13/10/2020

**Mount Thorley Warkworth Complex (SSD 6464 and SSD 6465)  
Rehabilitation Management Plan**

I refer to your letter dated 4 September 2020 and supplementary emails dated 18 September 2020 seeking the Department's comments on the revised Rehabilitation Management Plan (RMP) for the Mount Thorley Warkworth Complex which has been prepared in accordance with relevant requirements of the above development consents.

Attachment C:

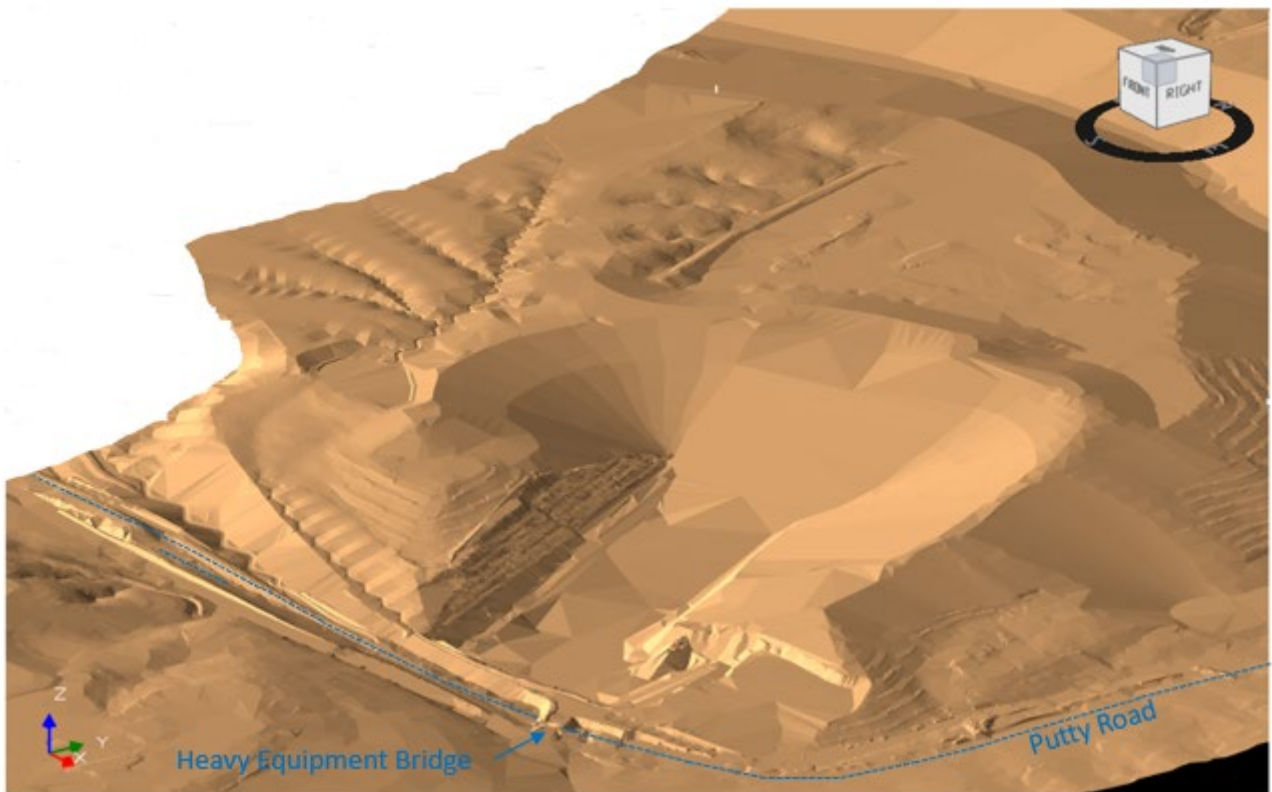
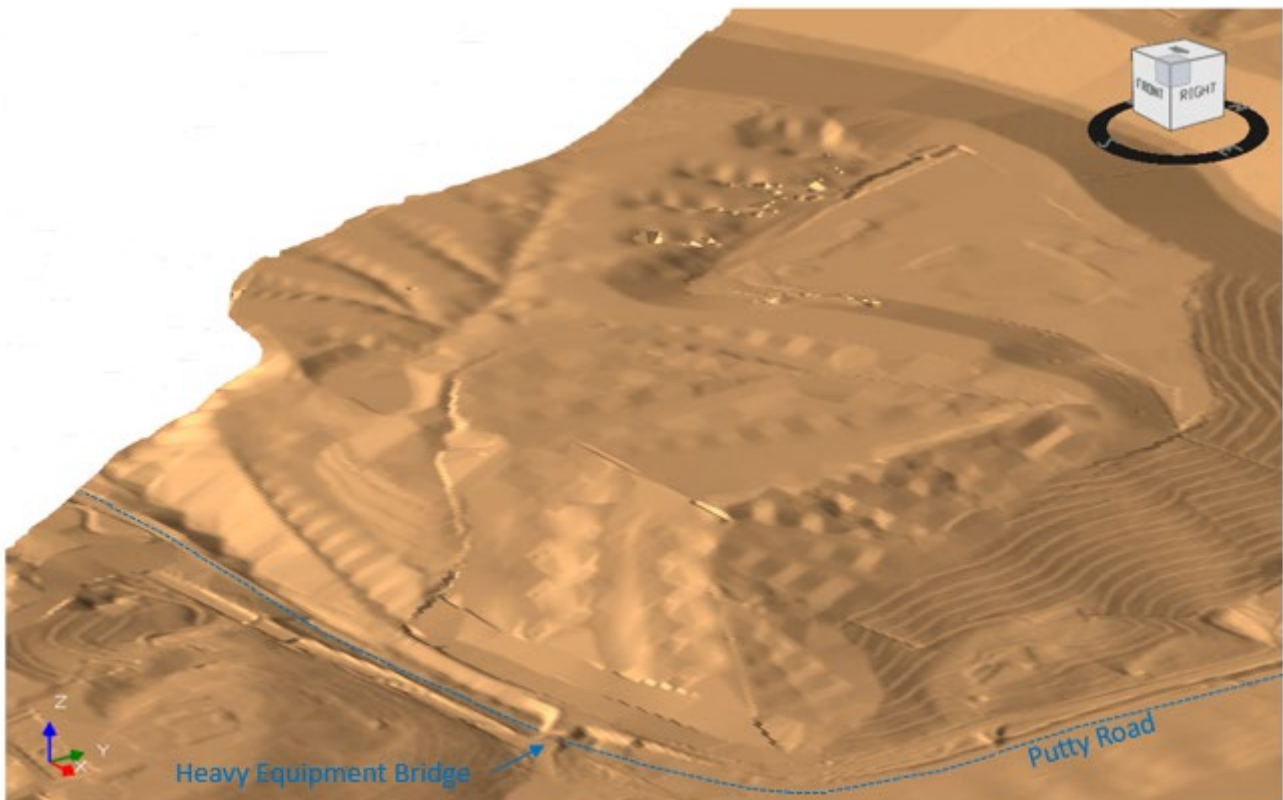
The Department considers that the emplacement of waste rock in the South Pit Void is generally consistent with the rehabilitation strategy described in the Environmental Impact Statement (EIS) for the Warkworth Continuation Project (dated June 2014). The Department is also of the view that the partial backfilling of the void would be more consistent with the rehabilitation objective of minimising the size and depth of final voids, as outlined in condition 56 of Schedule 3 of SSD 6464, than the Indicative Final Landform shown in Appendix 6 of the development consent.

The Department notes that the proposed partial backfilling of the South Pit Void is an interim measure, pending further investigation regarding the potential for future underground mining with access via the residual South Pit Void. If an underground access is not required, the Department understands that the South Pit Void is intended to be fully backfilled. You are requested to continue liaising with the Department and other relevant agencies, including the Resources Regulator and Mining Exploration and Geosciences within Regional NSW, regarding the progress of these investigations.

The Department also notes that, notwithstanding any statements in the EIS, no tailings should be emplaced in the South Pit Void without further consultation with the Department and other relevant agencies and appropriate revisions to the Complex's Water Management Plan.
